Our Ref: PSM4010-008L

**RE: 44 CLUNIES ROSS STREET, PROSPECT
RESPONSE TO COUNCIL QUERIES**

This letter presents the response / discussion by PSM to both Blacktown Council and Cumberland Council queries received for the proposed development. The queries relate to the influence of the proposed development on groundwater. The work has been undertaken in accordance with the fee proposal PSM4010-007L, dated 20 October 2020 and approved on 6 November 2020 by David Lousick. Please do not hesitate to contact us if separate letters need to be prepared and issued to separate Councils to address the queries.

PRECISION COMMUNICATION ACCOUNTABILITY		DRAWING TITLE STORMWATER DRAINAGE LONGSECTIONS
	DRAWING No	C013251.06-C43	ISSUE 1

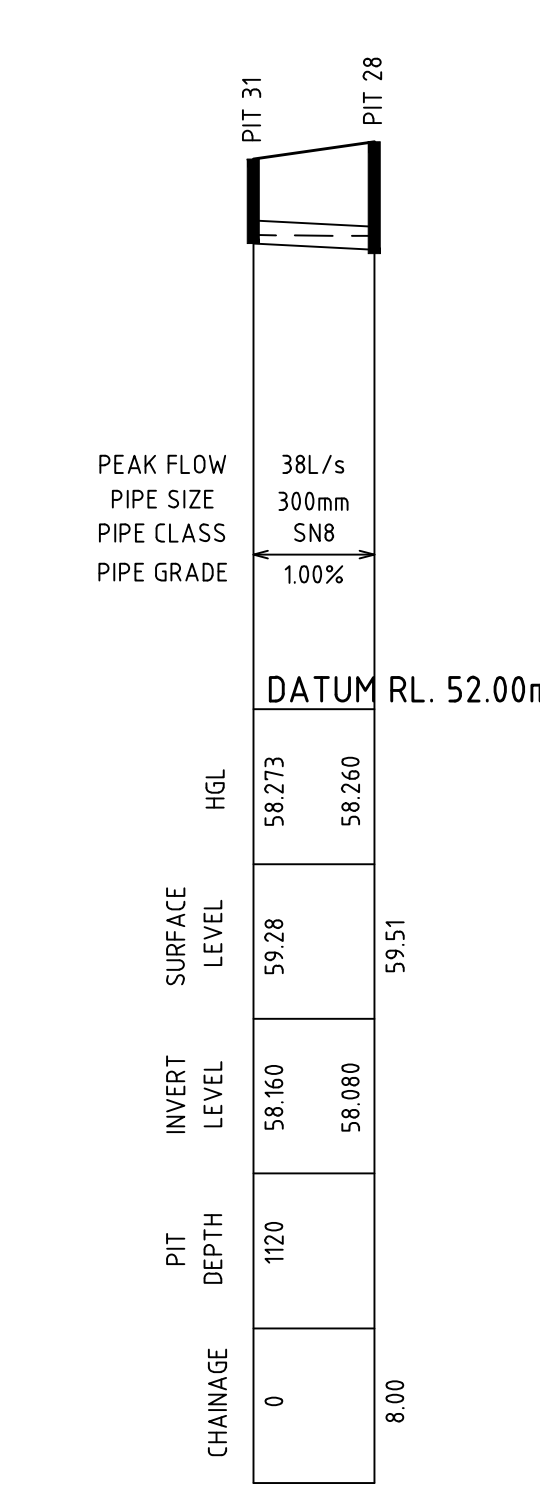
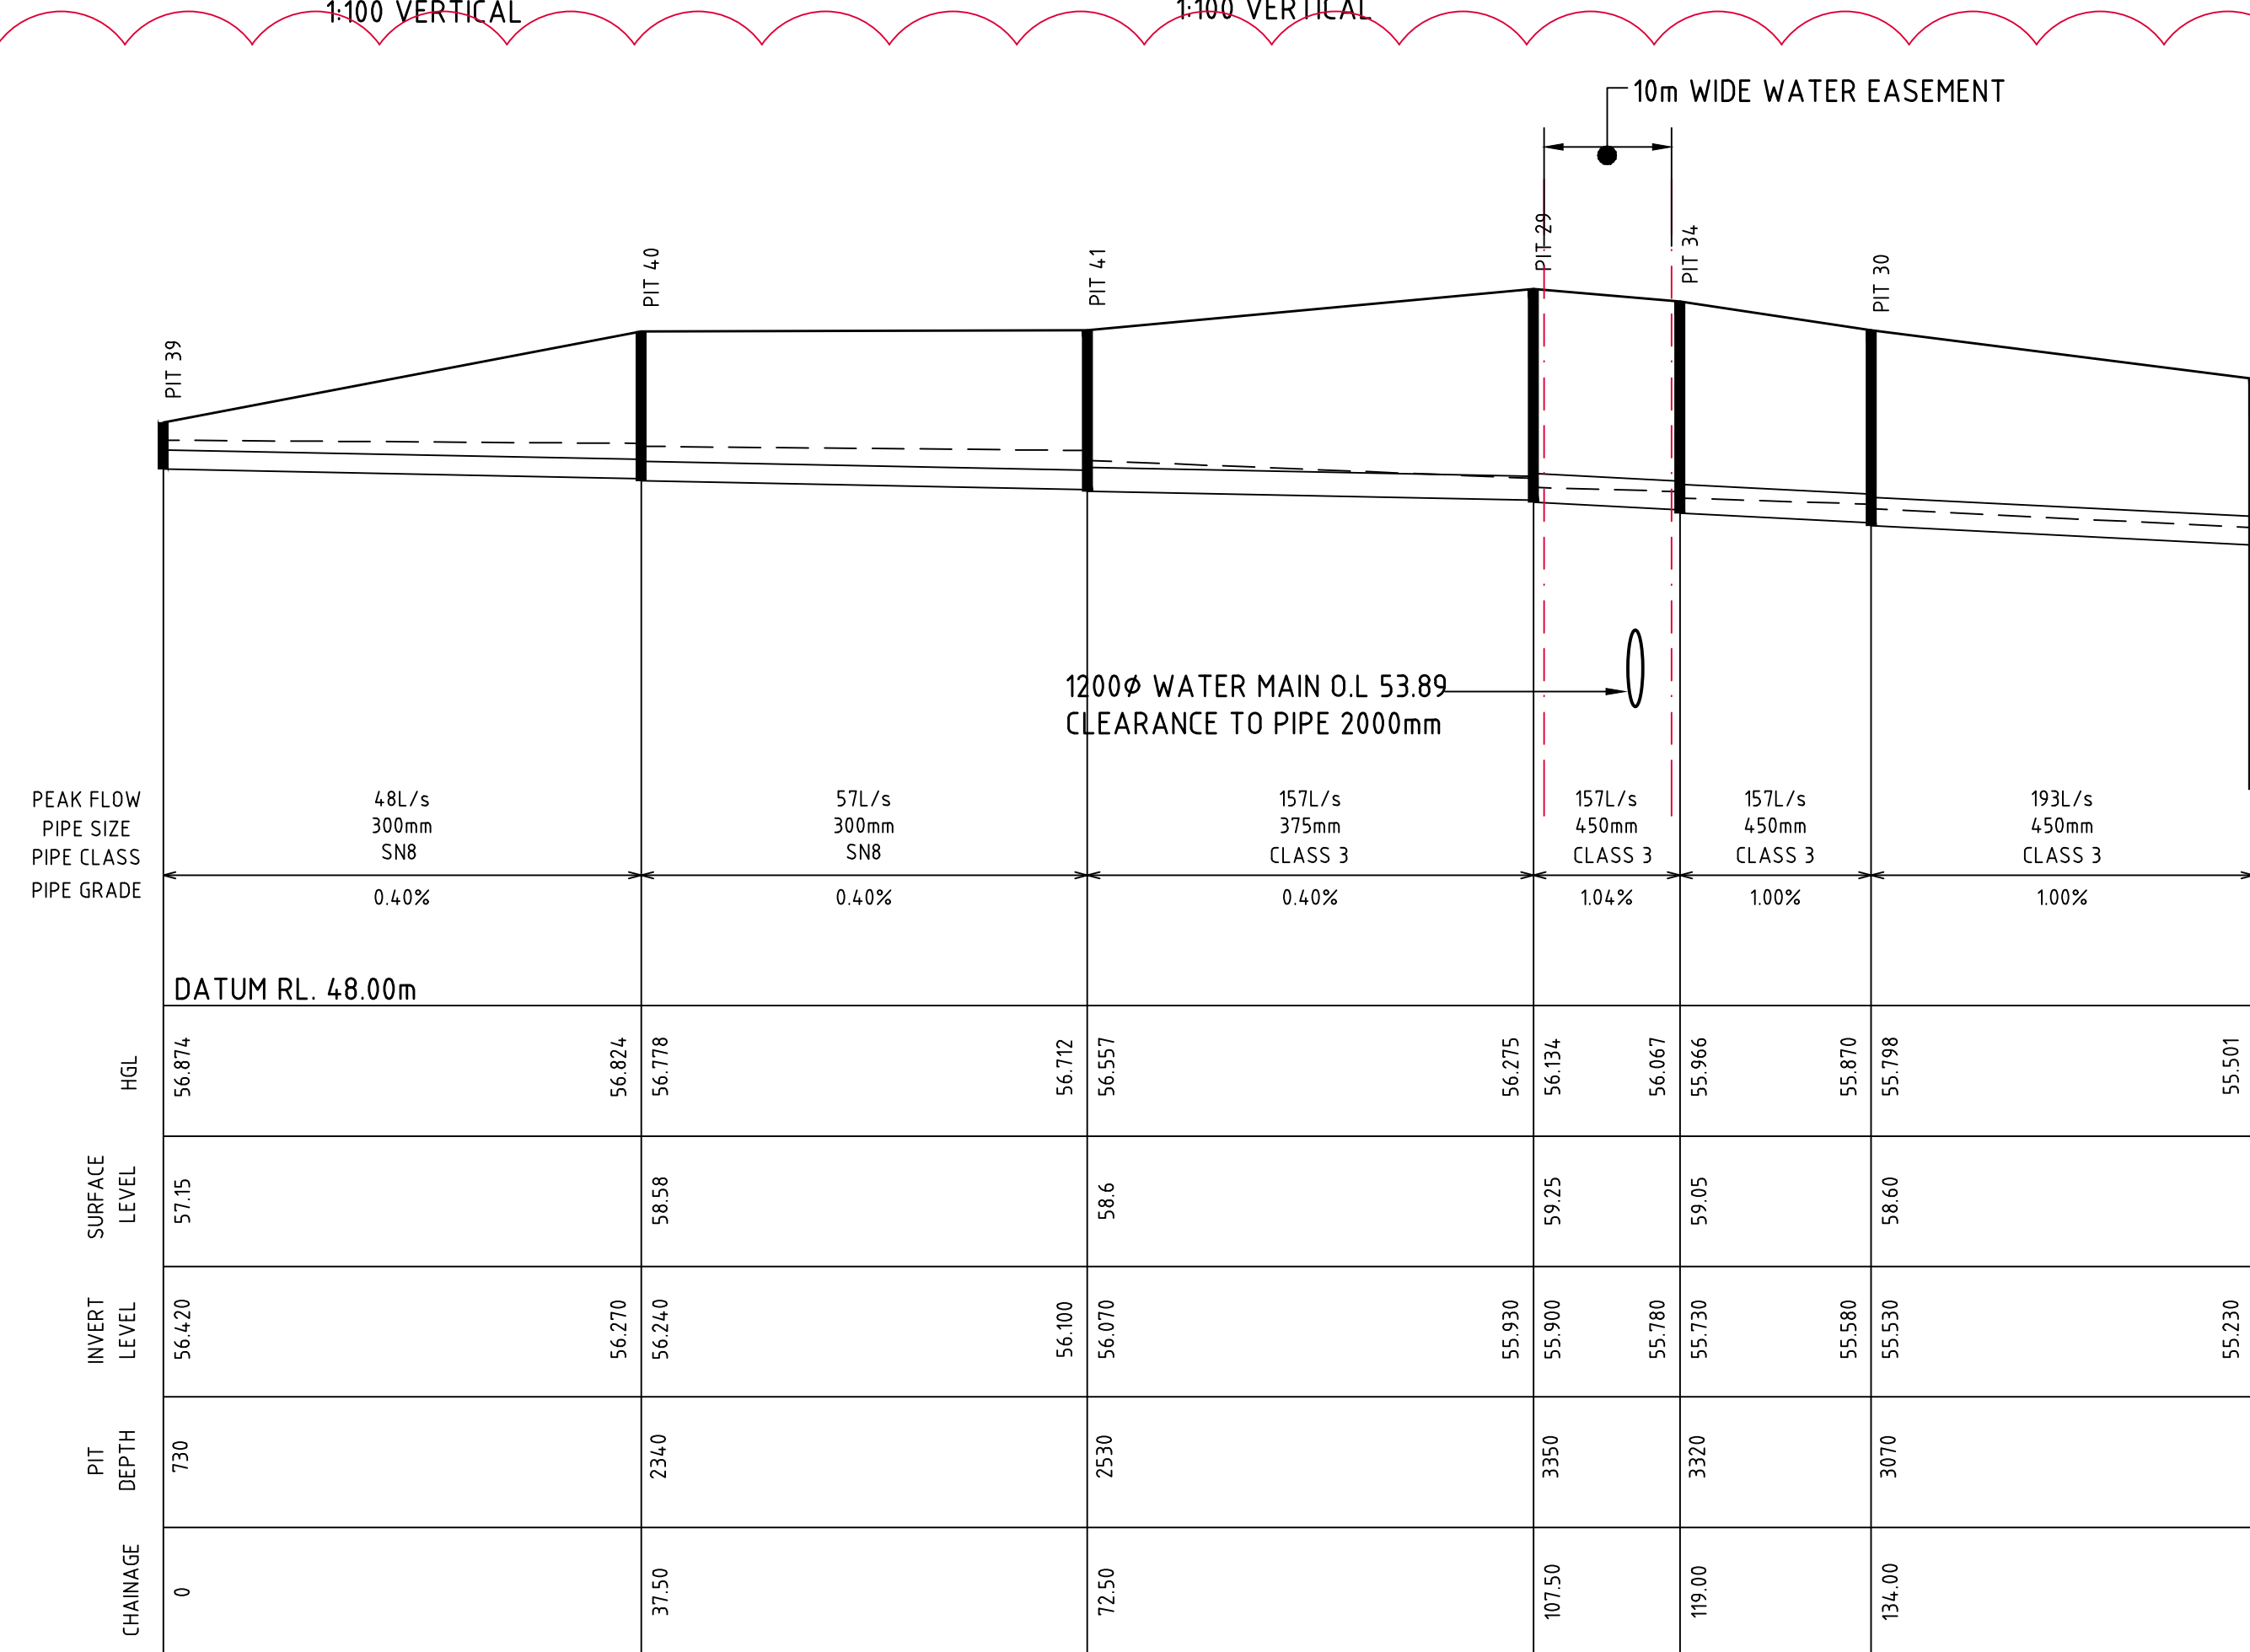
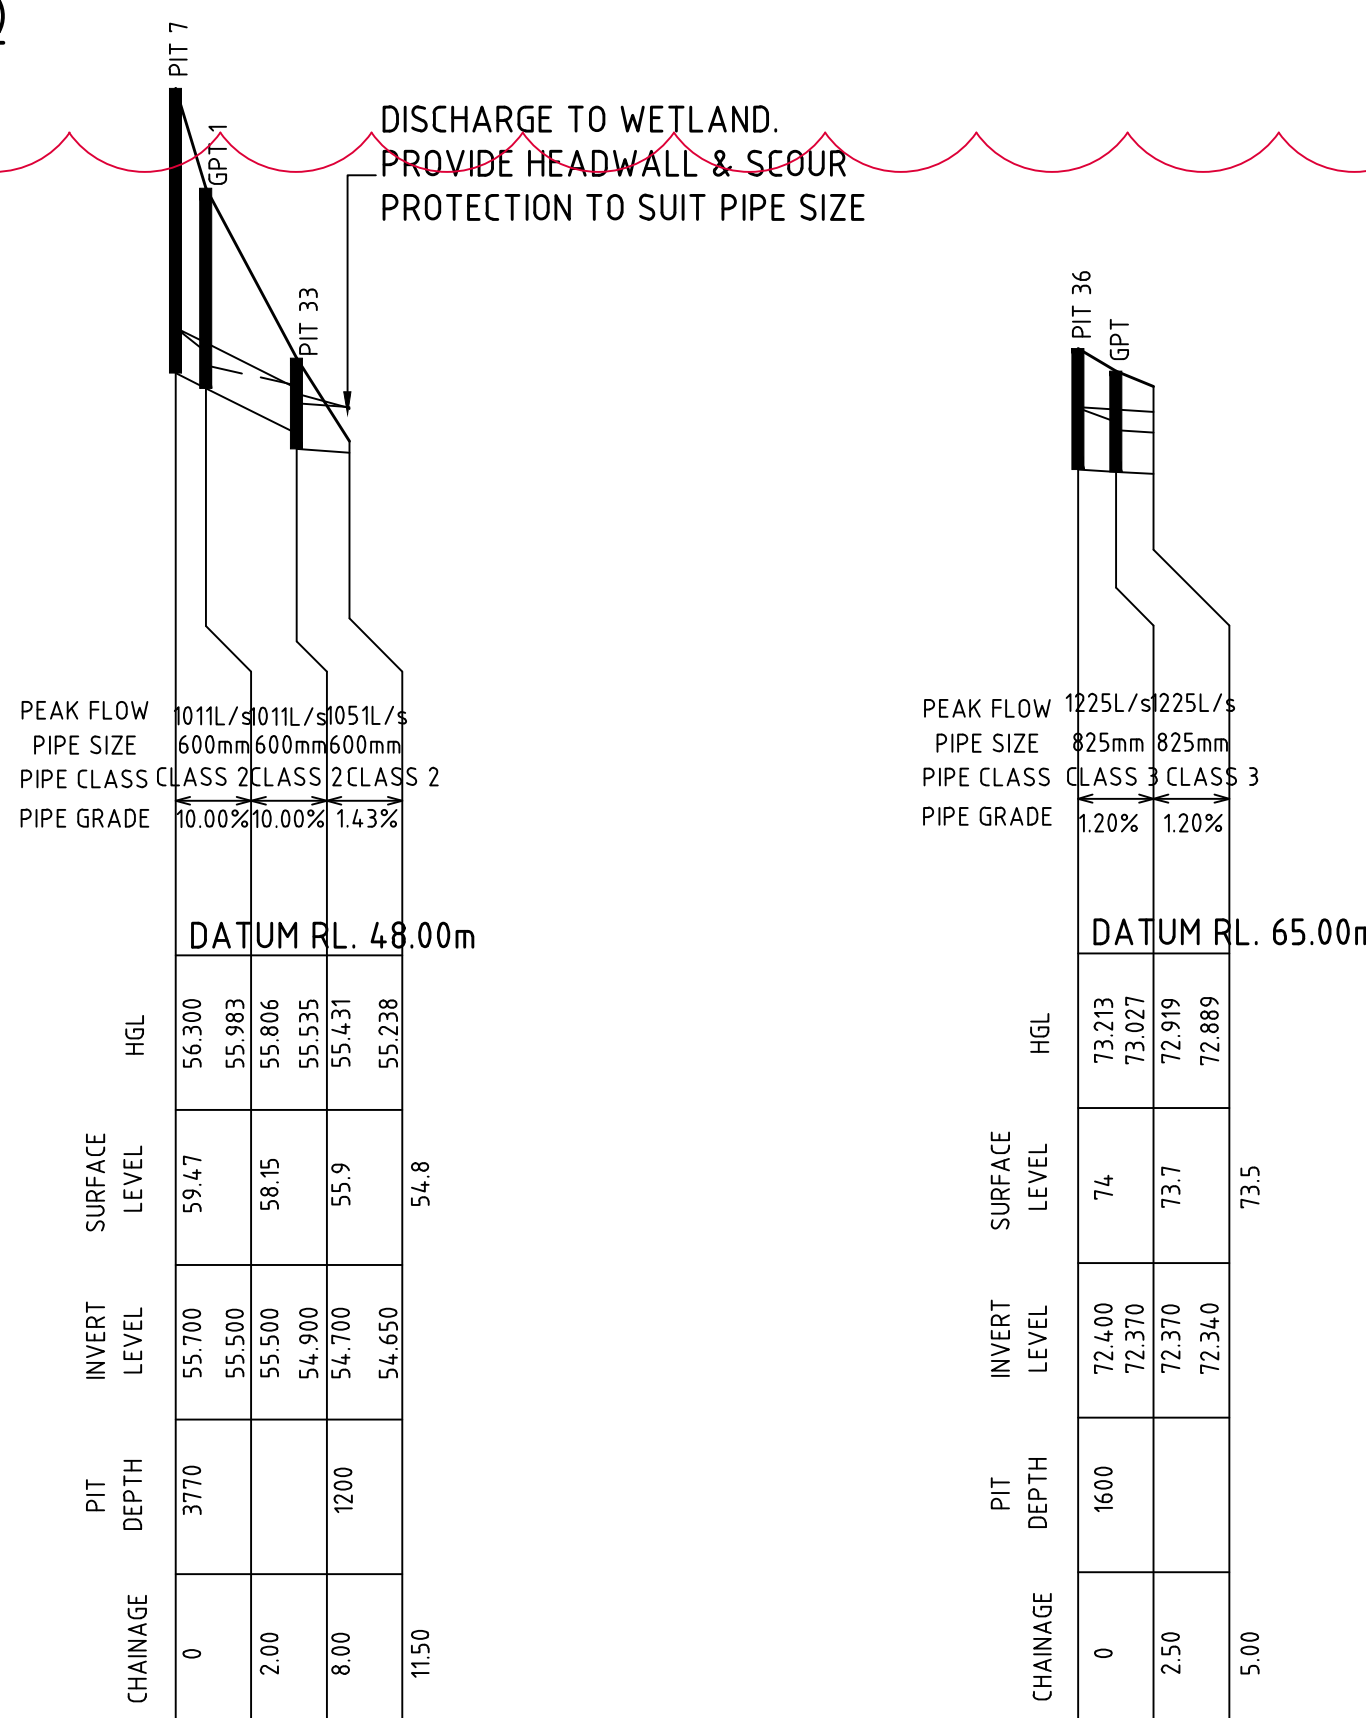
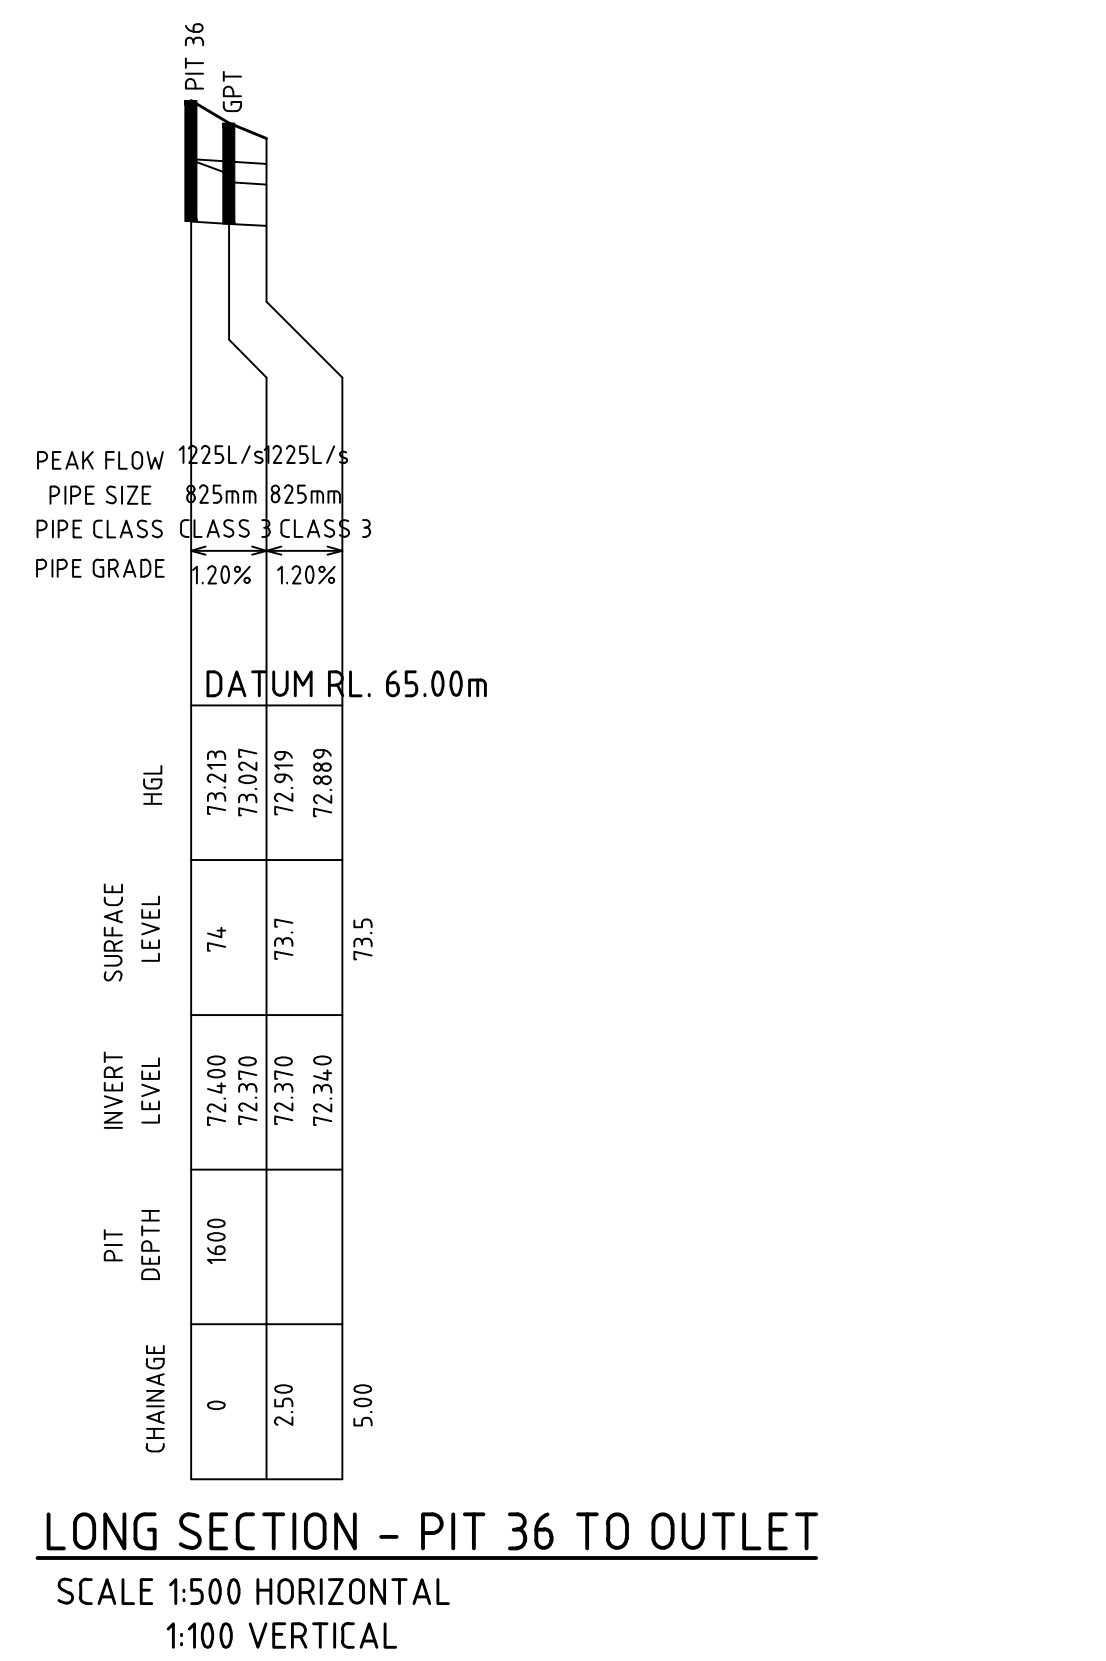
“Geotechnical Investigation report by PSM (dated 11 February) has suggested that Groundwater seepage was encountered at boreholes conducted onsite (boreholes 2020/BH09 and 2020/BH10). Results and recommendations carried out in this report must be considered (i.e. excavation methods, batter slopes and heights above the groundwater table etc) for the civil engineering designs.

Since these boreholes were tested at the location of proposed building pads (i.e. Pad 7), further investigation and possibly long-term groundwater monitoring is required to ensure that the proposed development does not impact the groundwater table and groundwater flows”

Based on the Costin Roe civil drawings CO13251.06-DA10D to F02B, dated 3 June 2020, we note the following:

- The majority of the Pad 7 area is proposed to be filled with the exception of the foundations for the proposed retaining walls, the stormwater basin to the north west of site and underground services which will require excavation prior to placement of structural fill, Inset 2 and Inset 3.
The excavations are likely to encounter groundwater during construction and temporary surface and sub-surface groundwater control measures will be required.

- The depth to groundwater may be shallower in proximity to the water storage (reservoir), Inset 1, which at the time of survey / measurement had a water level in the order of RL 54.6 m AHD

- The civil and structural designers shall consider the influence of the Girraween creek and associated stormwater infrastructure on temporary groundwater levels during peak flows. i.e. the embankment crest within Girraween creek is at approximate RL 57 m AHD ,Inset 1

- In the south east of the Council area, Inset 2, the proposed bulk earthworks level for Pad 1 is at RL 57.20 m AHD which is above the observed groundwater levels and that of the water storage. The civil and structural designers shall consider the advice for temporary and permanent control of groundwater provided in the IGDA (PSM4010-004L Rev1, 26 November 2020).

- In areas above the permanent groundwater level, allowance for seepage during periods of wet weather during construction and in design shall be included.
